MEMORANDUM

Date: Dec 10, 2014
Project: 97 State Street, Portland, ME
From: David Tetreault
Subject: Response to Building Dept. Review Comments

7 | STRUCTURAL SECTION
1" = 1'-0"

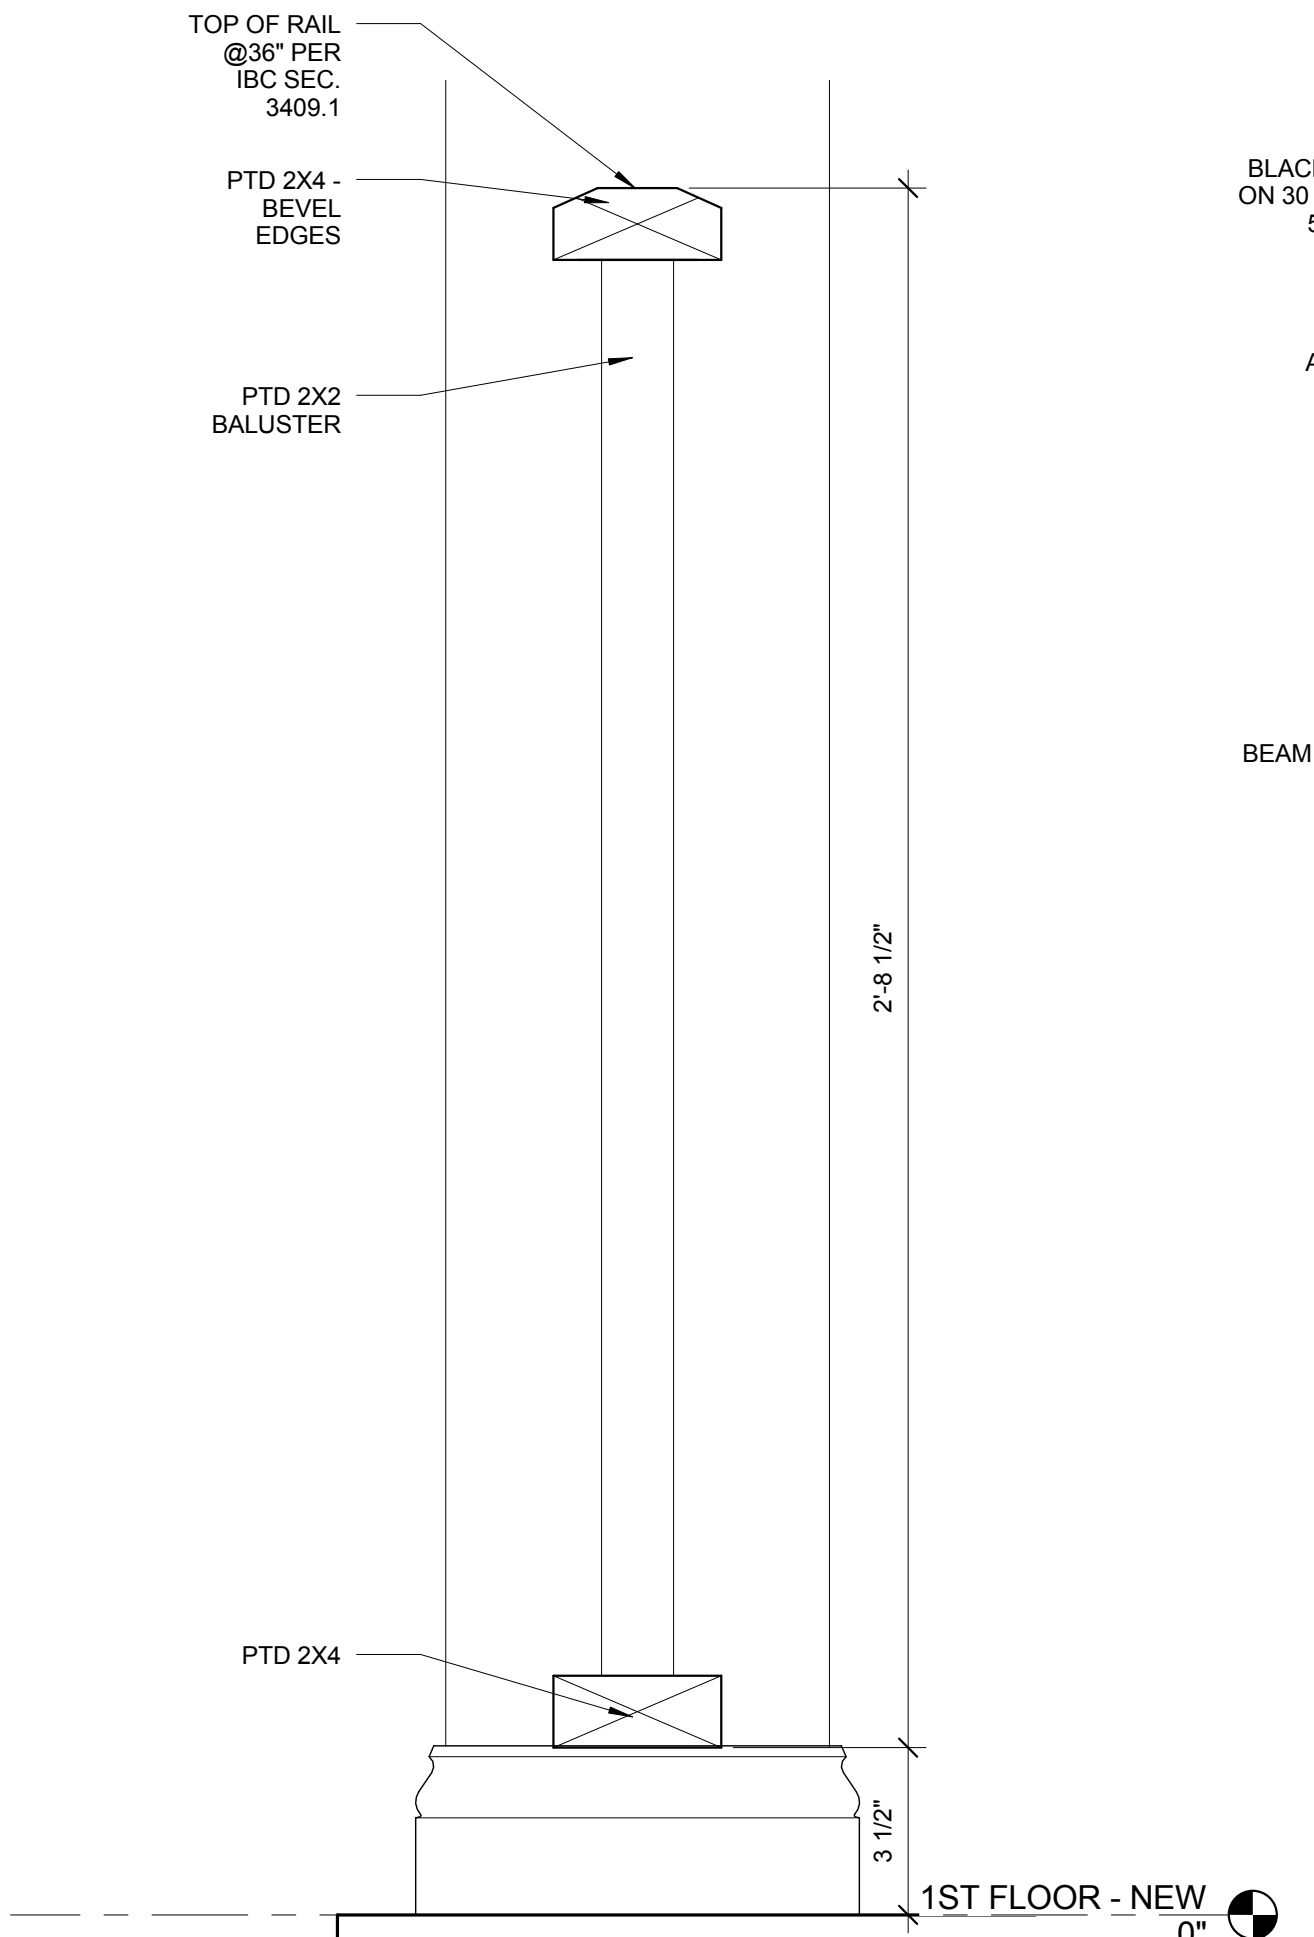
Attached are calculations that I prepared for support of the exterior porch floor beam as shown on Structural Section 7/A2.01. Following are the design criteria used:

Floor Dead Load	12 PSF
Floor Live Load	100 PSF
Fastener Allowable Shear	940 Pounds

FASTENERS REQUIRED = $\frac{2653}{990} = 2.8$ USE (3) TLOKOG
